From: Anita Gardner
Sent: 22 May 2019 15:55
To: Planning.Responses
Subject: FW: R/72/19/PL - 2 New Dwellings - 6 Manor Road, Rustington
Attachments: 6manorproposedelevs REV3.pdf

Please treat as a substitute plan

DRAWING No: DS/6MANOR/03 rev 1

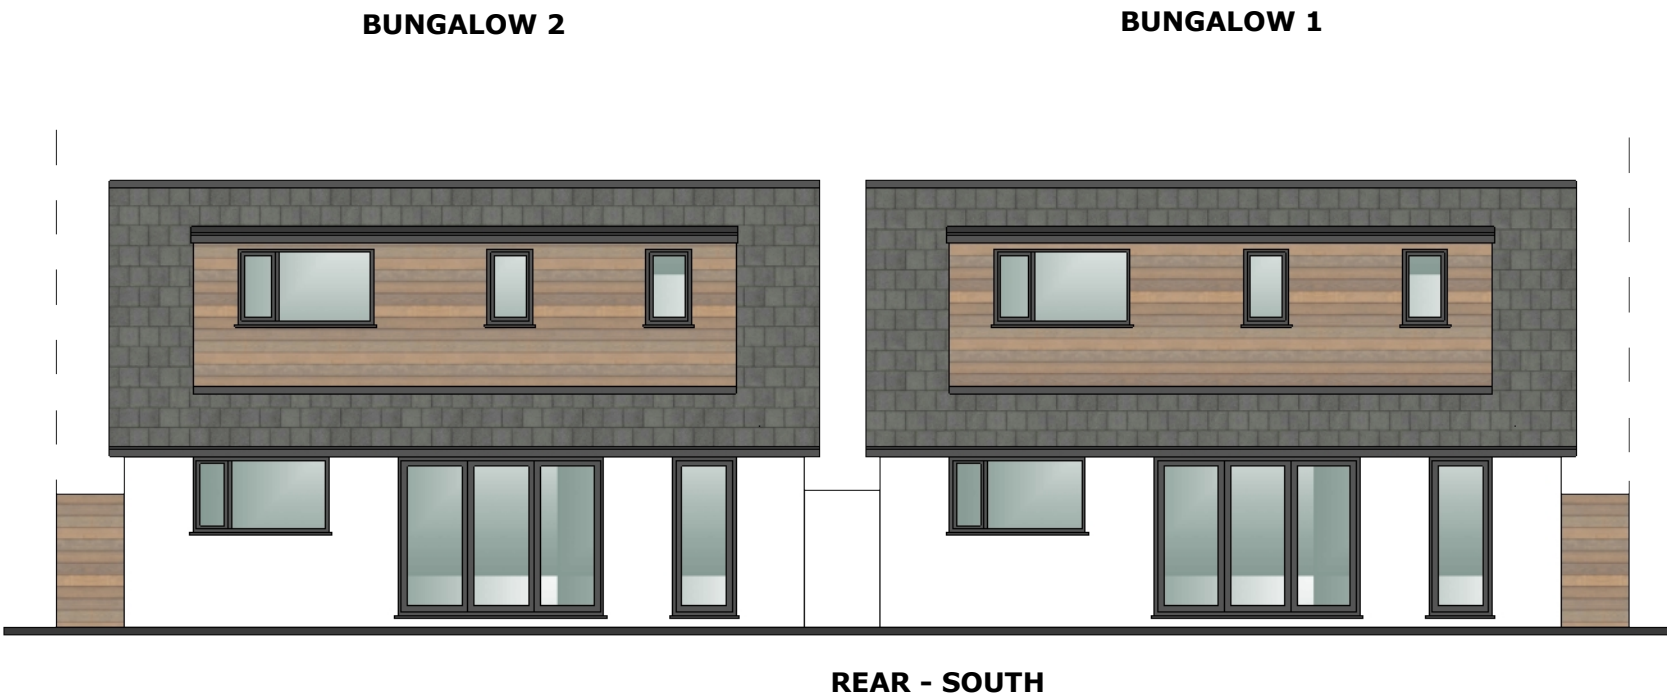
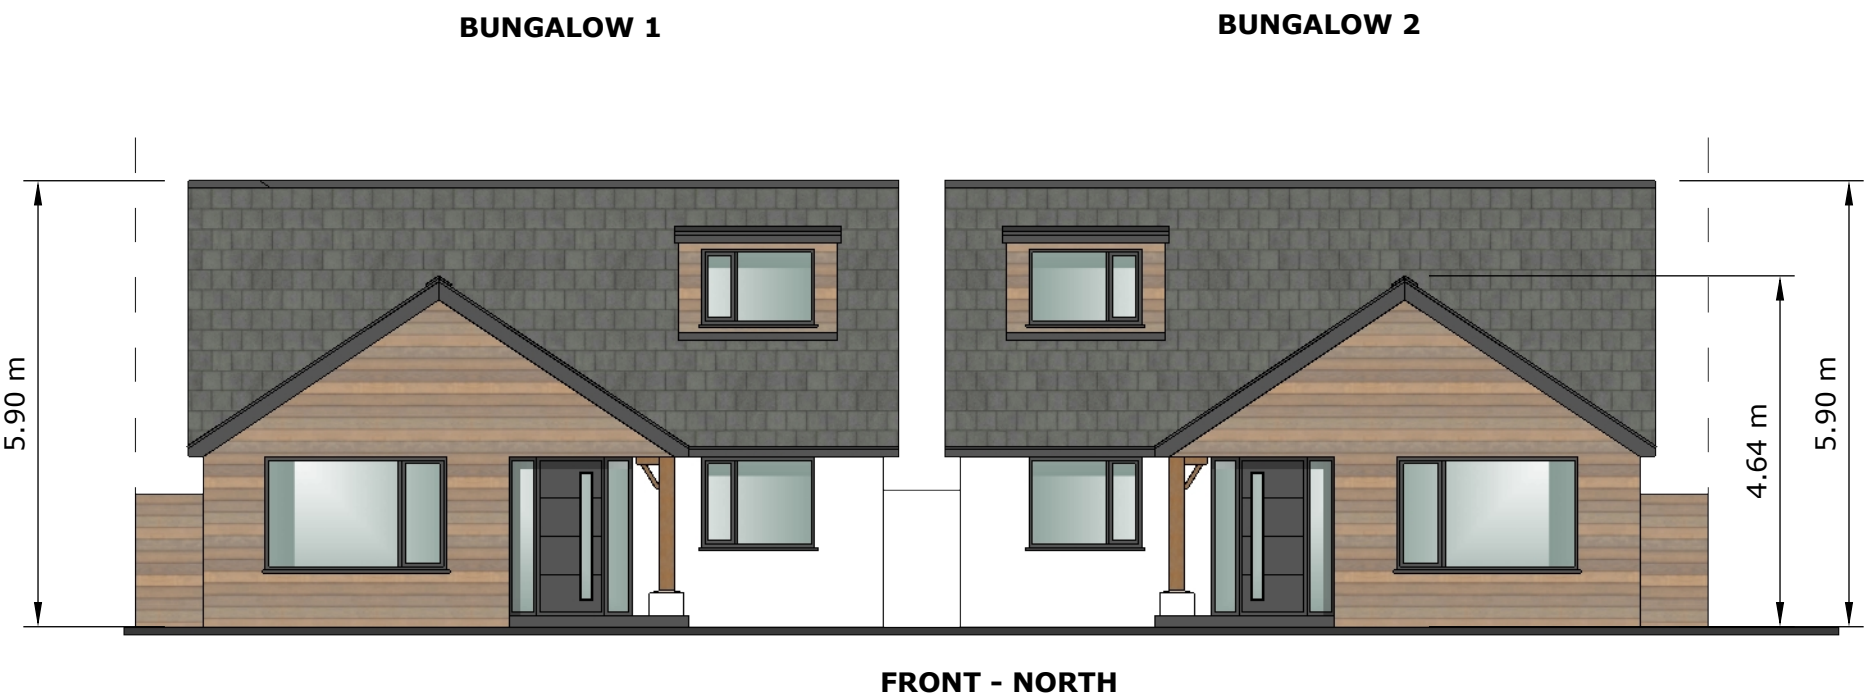
There are still inaccuracies in the plans. There still appears to be a discrepancy between the plans and elevations. The front elevation shows the plots mirrored like the site plan, however the back elevation is not mirrored. The plot furthest from 1 Grafton Close is correct but the one nearest is a repeat of the other plot. Is this correct or should the back elevation be mirrored to match the floor plans? This has overlooking implications if there is a main bedroom on the rear and not two bathroom windows.

The ridge height has been reduced to 5.9m, however the ridges are still around 0.95m higher than the adjacent bungalows of Grafton Close. 1 Grafton Close has a ridge height is 4.95m, but the new street scene shows the height at 5.15m when scaling the drawings, which is incorrect.

My apologies I must have neglected to flip the handing and not noticed so well spotted! Please see attached amended version.

We had no access to physically measure 1 Grafton Close so we estimated as closely as possible based on number of bricks plus the ridge tile to get to 5.15m. Is your suggested ridge height of 4.95m a site measured one? If you have been able to measure and are confirming 4.95m I can change this on my drawings and re-send.

In regard to windows at the rear, we can look at options for obscure glazing/removal/re-positioning etc if you feel there is an overlooking issue. There would be no possibility of viewing into the property at No 1 and in terms of the garden space this is already overlooked quite closely from the properties to it's rear. Please let me know if you feel differently and need me to have a look at this.
